Planning Application No: 3/2024/0121
Grid Ref: 363889 439018

Proposal: Proposed extension of farmhouse and conversion of attached existing agricultural barn and adjacent agricultural building to form extended dwelling including creation of basement level with subterranean parking; demolition of other agricultural buildings and replacement with new agricultural stock shed with solar panels and new agricultural storage building to west of farmhouse.
Location: Cuckoo Hall Higher Road Longridge PR3 2YX

The Local Highway Authority have viewed the plans and highway related documents and have the following comments to make:

Planning Application  
 Proposed Site Plan  
 DATE January 2024

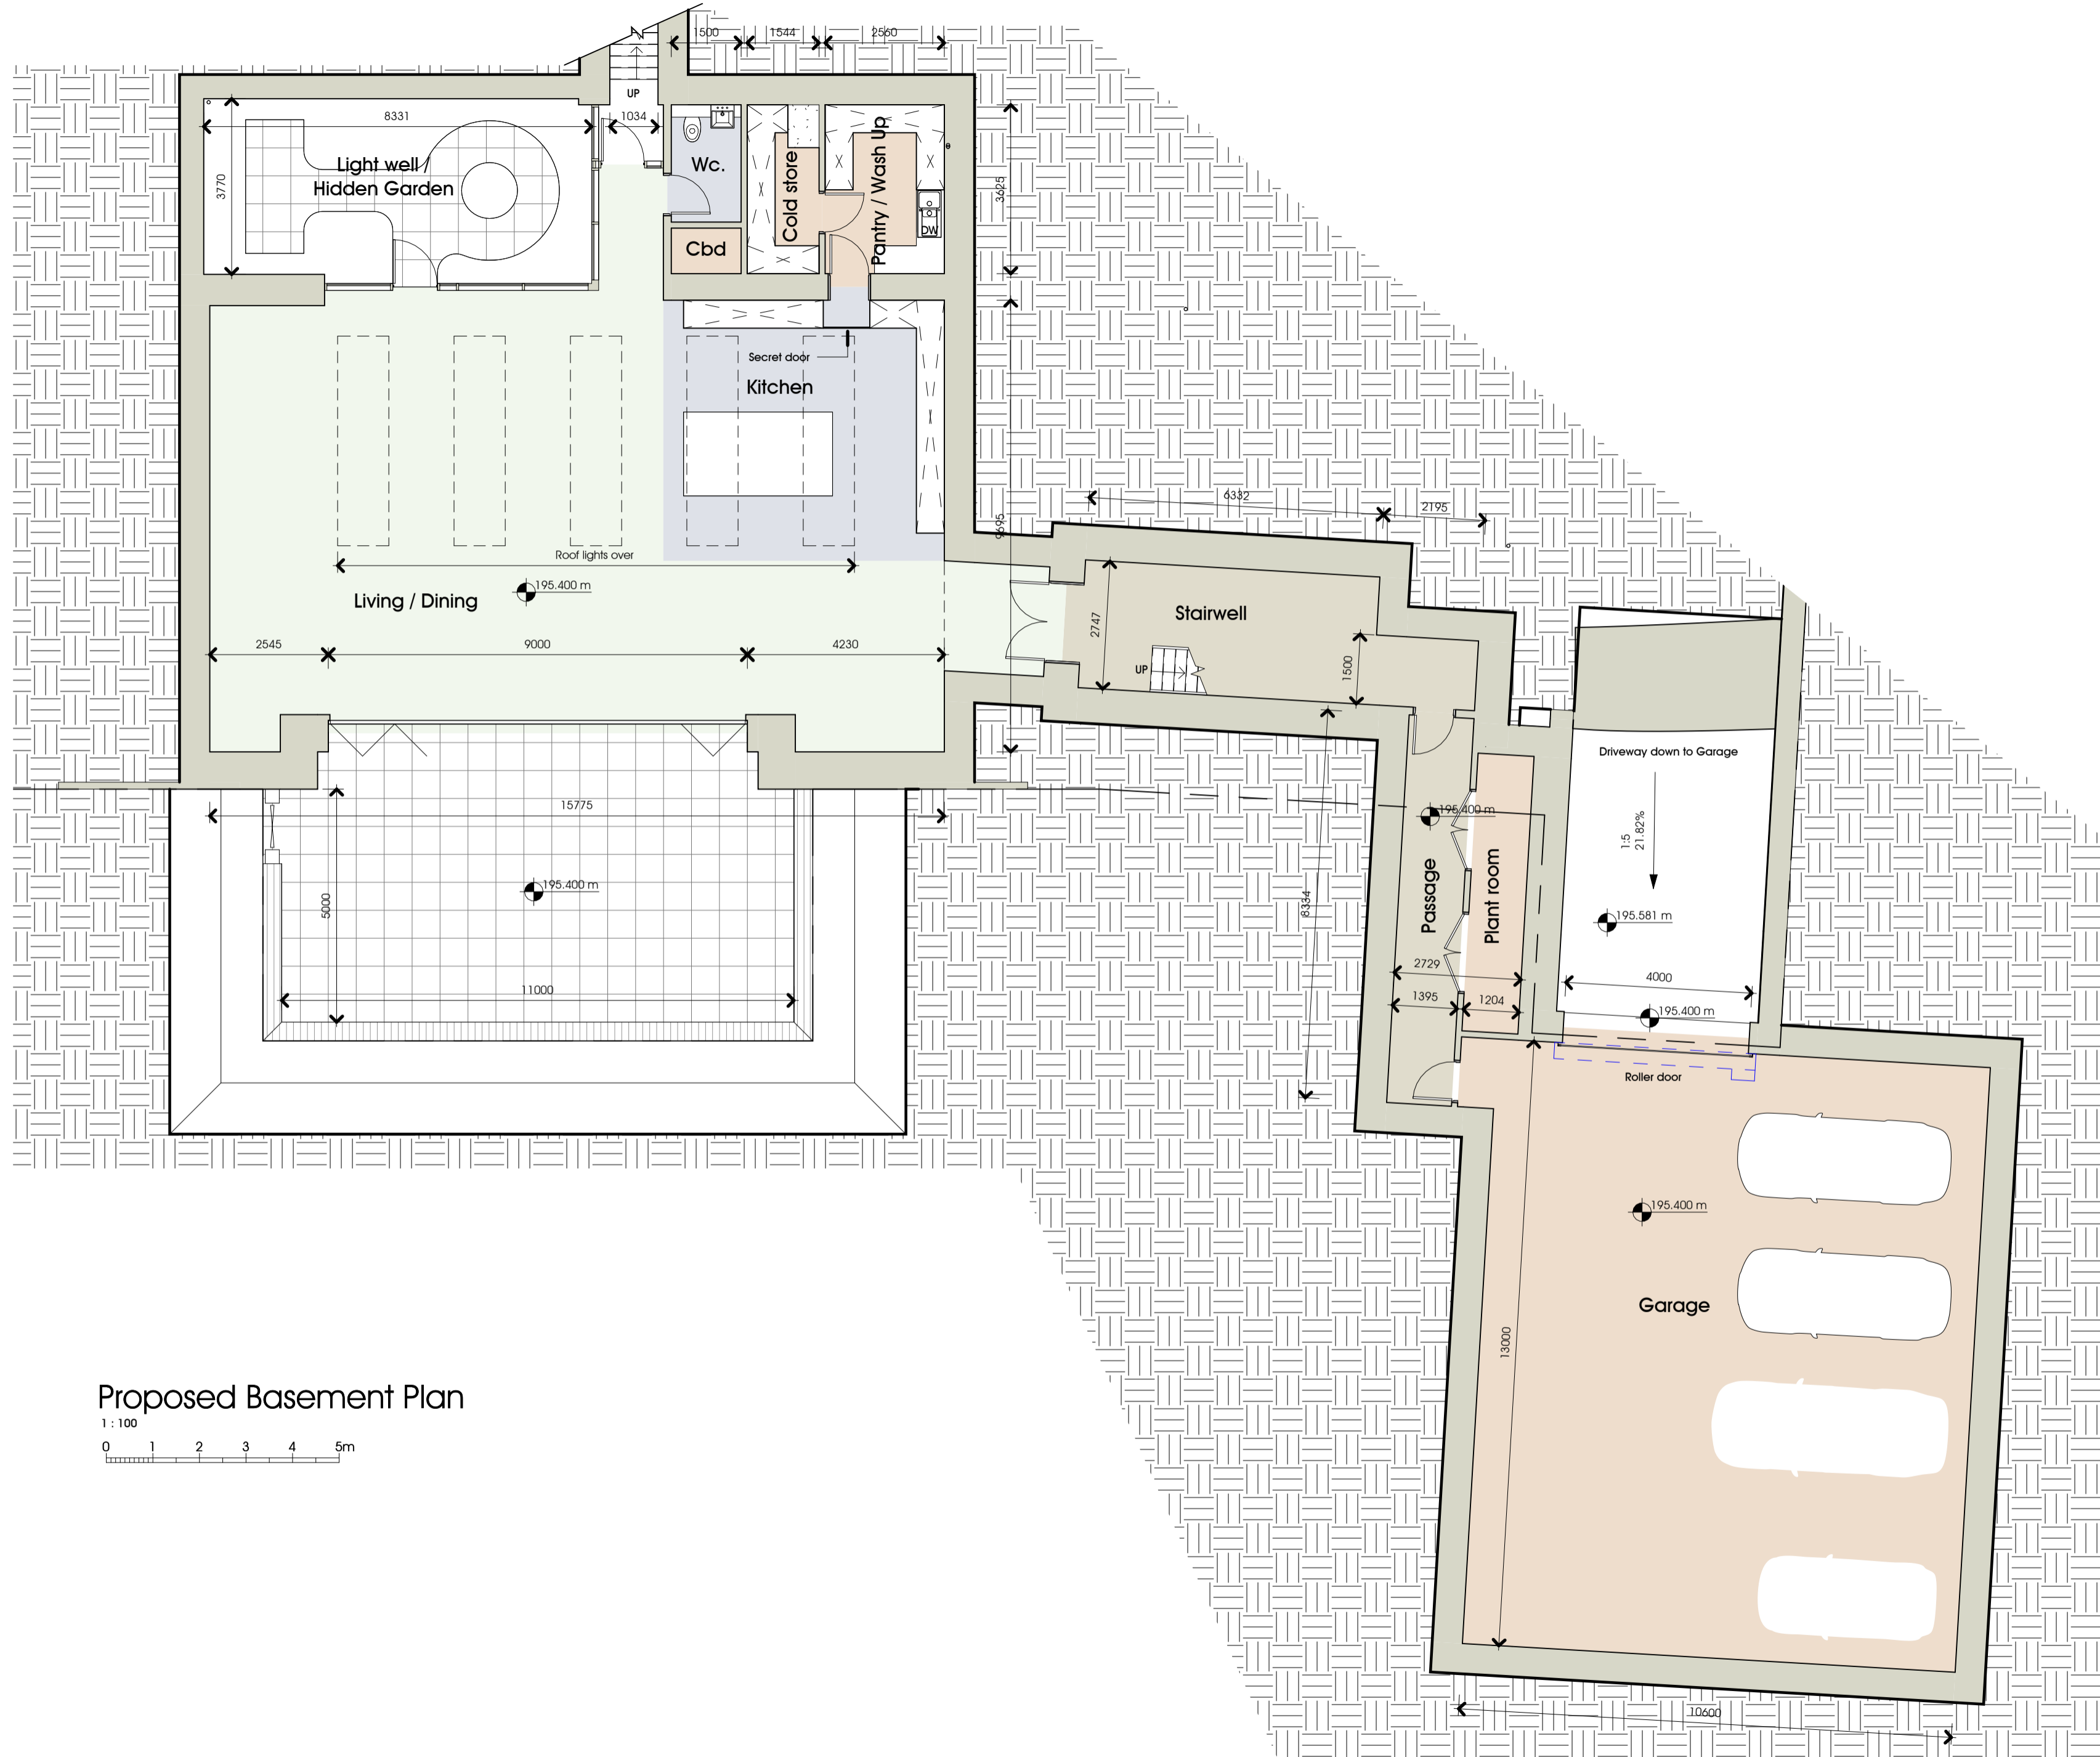
The LHA have reviewed drawing number PL-002 Rev A, Jan 24 titled "Proposed Site Plan" and have no comments to make regarding the access. This is because the existing access will remain unaltered following the proposal and this is considered acceptable.

The LHA have reviewed drawing number PL002 Rev A, Jan 24 titled "Proposed Site Plan" and are satisfied that the proposed parking arrangements complies with the parking guidance as defined in the Joint Lancashire Structure Plan. Therefore, the LHA have no further comments to make.

1. The development hereby permitted shall not be occupied until such time as the parking and turning facilities have been implemented in accordance with PGB drawing number 020. Thereafter the onsite parking provision shall be so maintained in perpetuity.
